From: Andrew Wood <Andrew.Wood@arun.gov.uk>
Sent: 21 November 2019 09:29
To: Planning.Responses <Planning.Responses@arun.gov.uk>
Subject: FW: WA/7/19/RES - Lanes End, West Walberton Lane - Additional information request

From: Mark Warwick <Mark.Warwick@arun.gov.uk>
Sent: 23 October 2019 13:02
To: Andrew Wood <Andrew.Wood@arun.gov.uk>
Subject: RE: WA/7/19/RES - Lanes End, West Walberton Lane - Additional information request

WA/7/19/RES - Lanes End, West Walberton Lane - Additional information request

PLOT 3 FLOOR PLANS AND ELEVATIONS

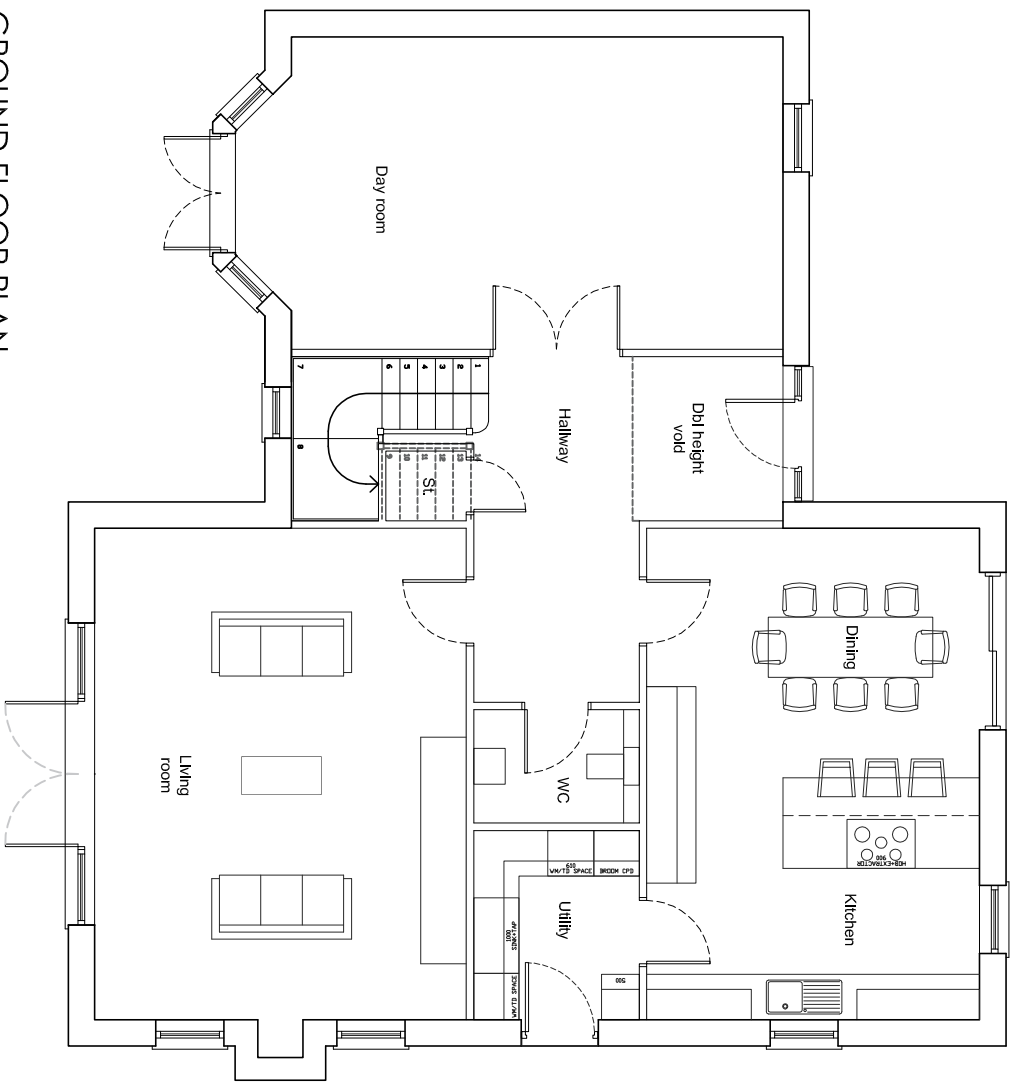
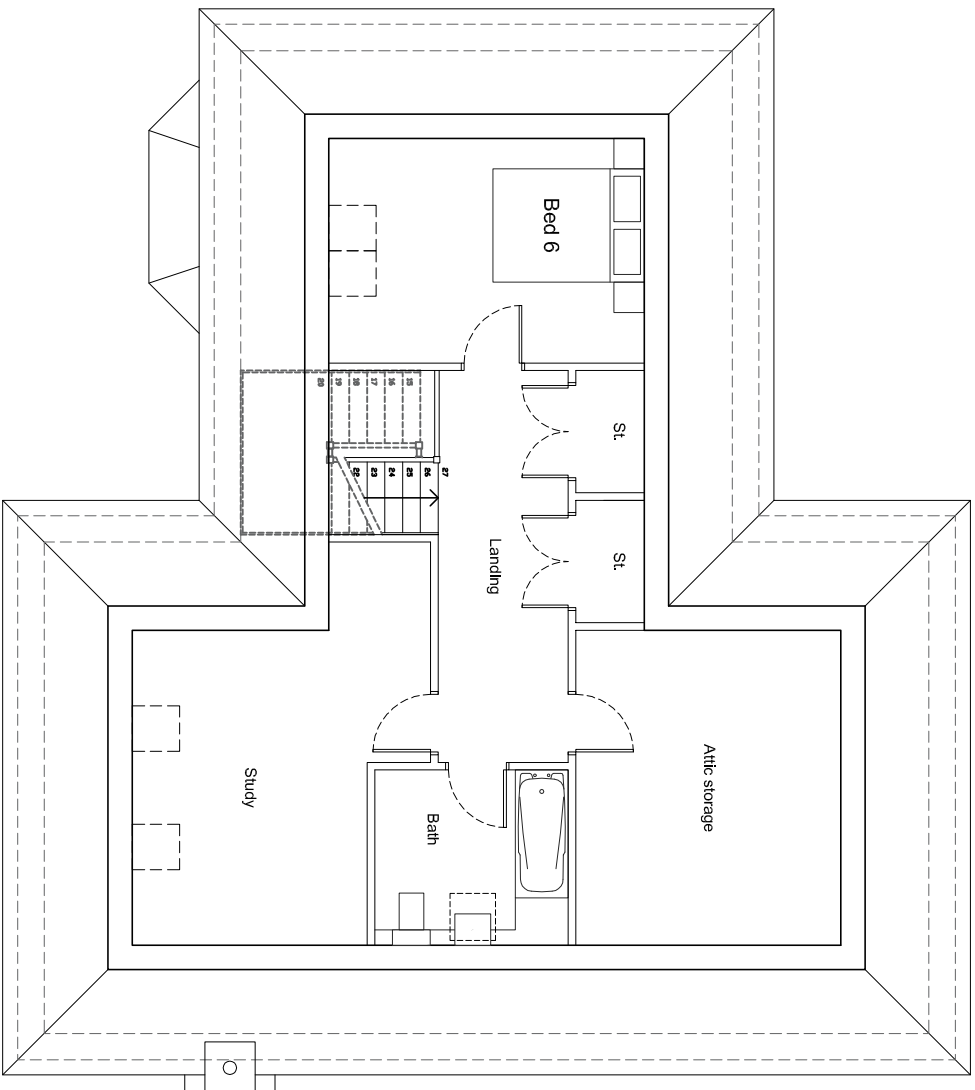
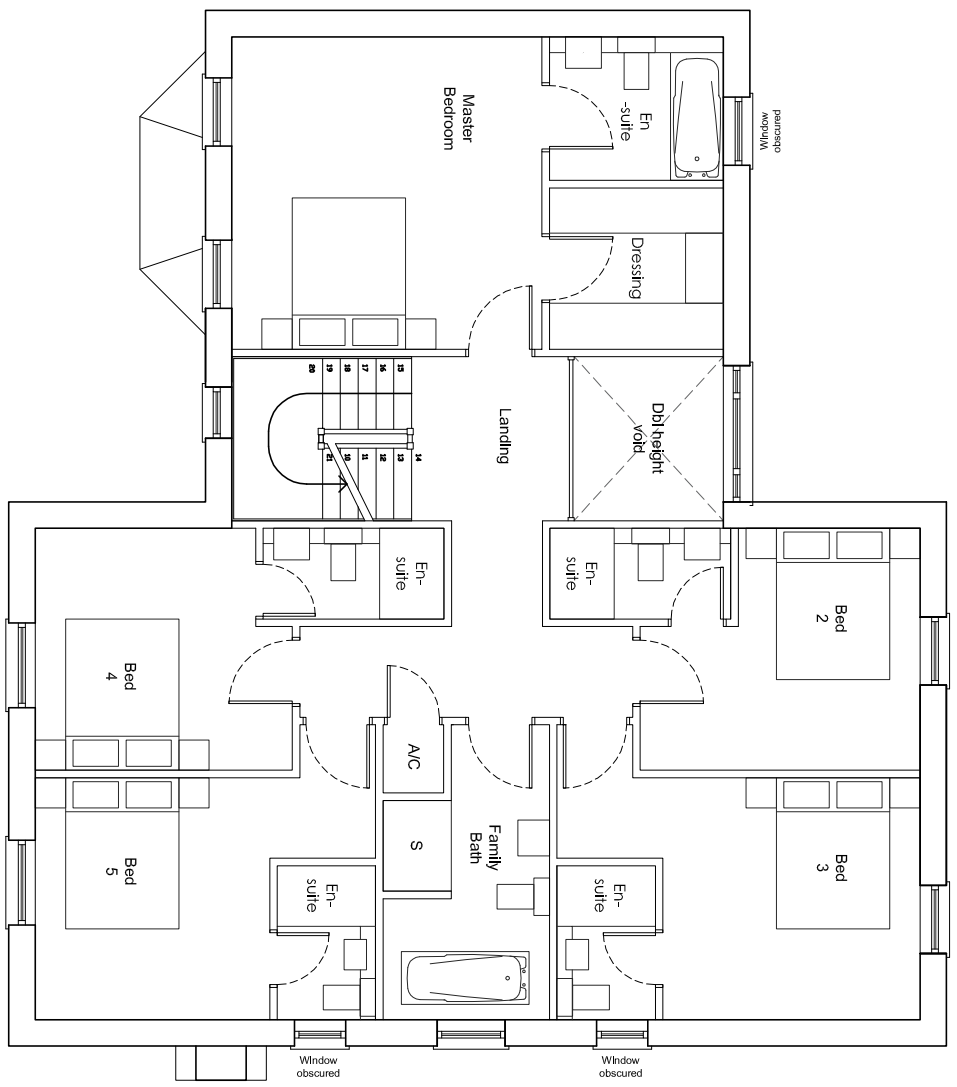
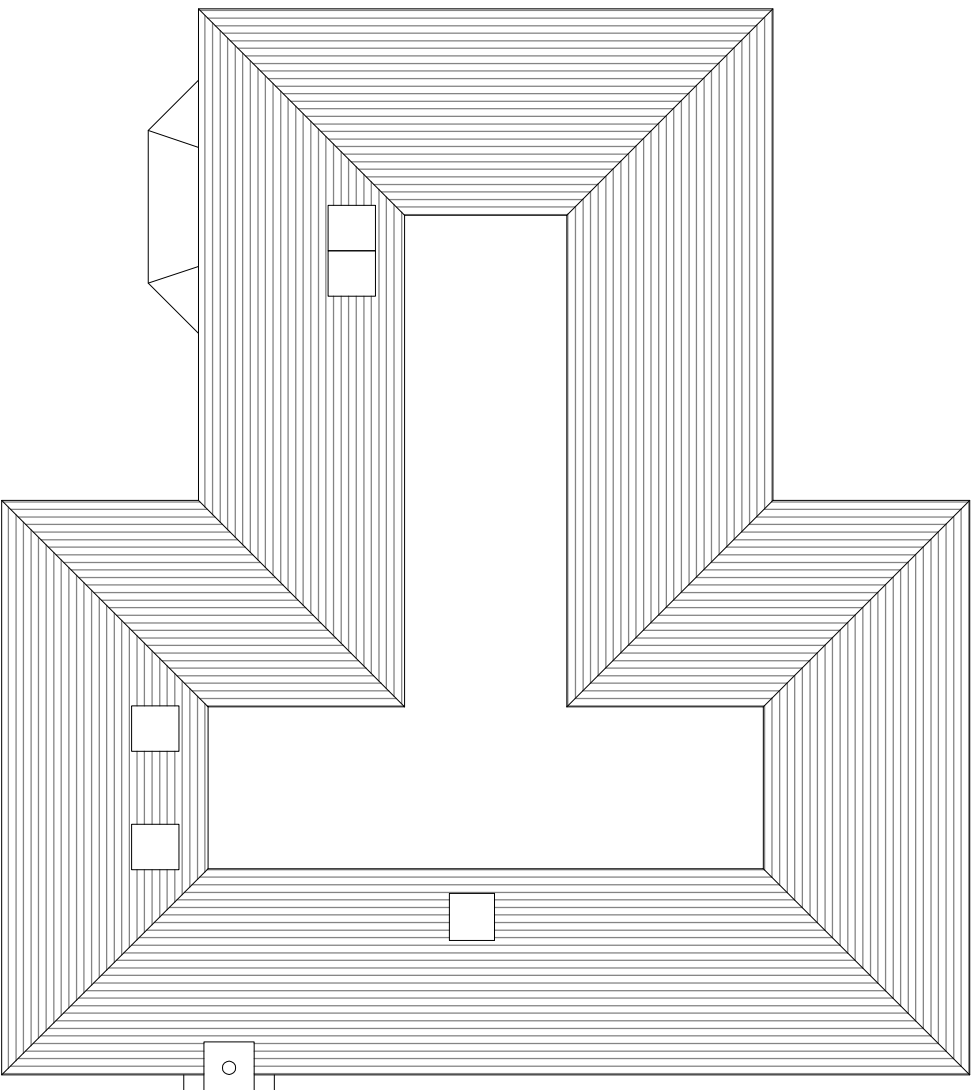
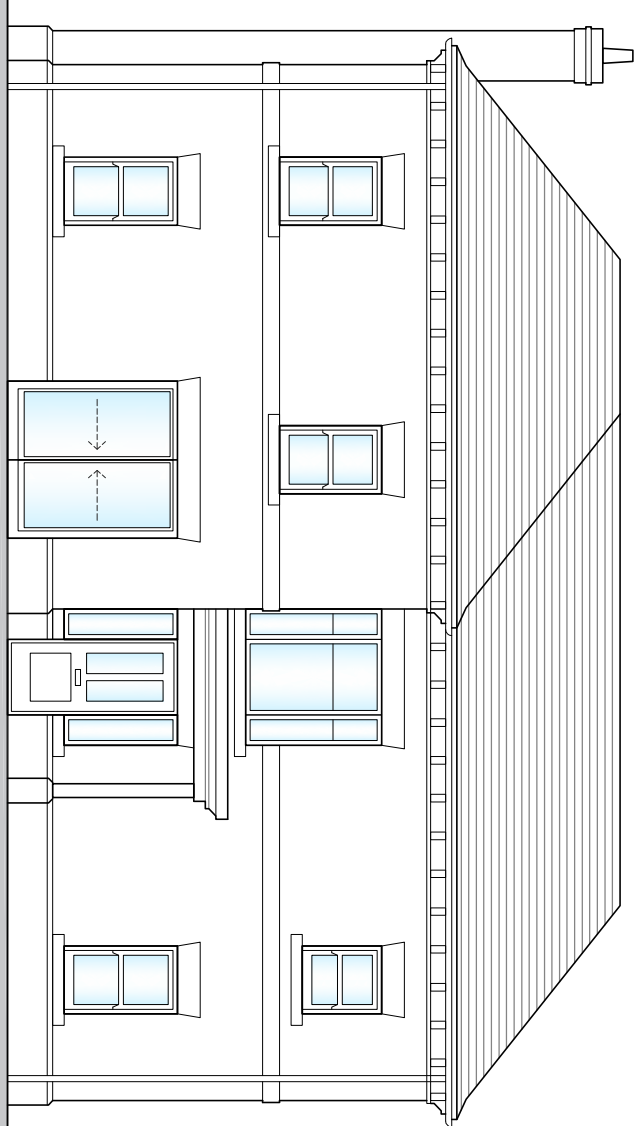
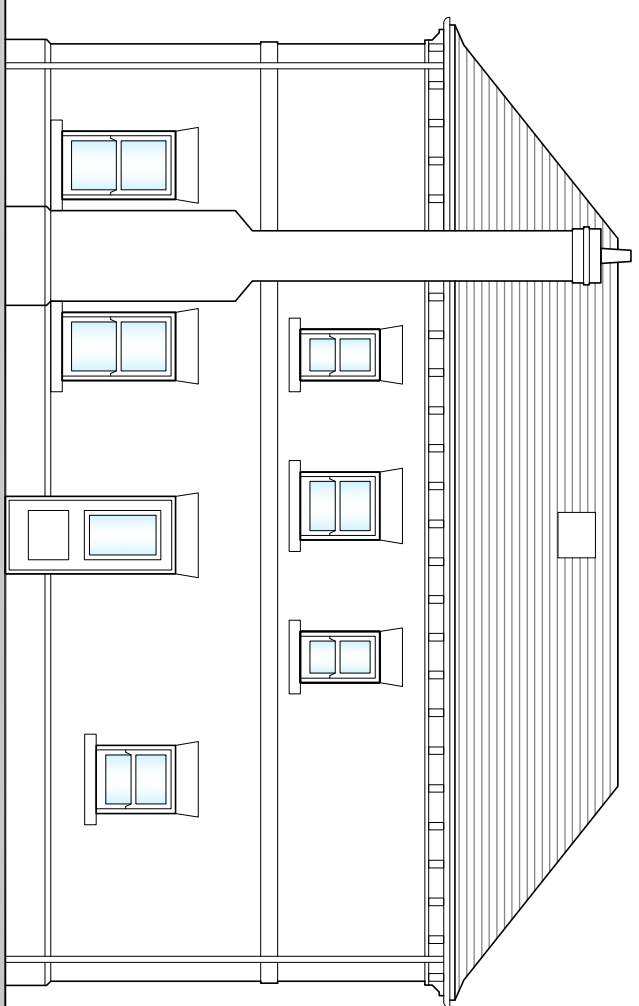
the issue with the rooms in the roof is that the appearance of the dwellings will be of a town house which is simply not appropriate in this location. I would strongly advise you to remove this element from the scheme. To avoid the risk of the development being viewed as 'out of character' in the area and contrary to policy D DM1 of the Arun Local Plan. I have discussed the matter with my line management team and everyone is of the same view in this case.

1. Amend the layout to ensure that a minimum of 9 metres exists on from blank gable end (or obscure glazed windows non opening below 1.7 metres in height) of nearest proposed house to gable end of 'Woodlands' which currently incorporates sole habitable room windows.
2. Remove second storey of houses/rooms in roof. 3 storey townhouses would not be acceptable in this location

2, we fail to see the merit in removing the room in the roof, this would have no impact on the height of the buildings and would result in empty lift spaces which would not allow for good use of space as per the NPPF. You will note from drawing 19-001-PL-03 all the dormers on houses 3-6 are in the south and therefore can not be seen from the front or any point outside the properties. Currently prosperities one and two have the dormers on the north but I would be happy to move these to the south so these are the same and none can be seen from Arundel road. I also would like to mention the design of white cottage next door that will have dormers in the roof and Richmond house which has velum windows in the roof. As previously mentioned the new ridge heights will be lower than the current house at Lanes end this can be seen in the scale drawings provided. If you could let me know if this is acceptable as if possible to avoid I would prefer not to have to appeal the reserved matters for this small item.
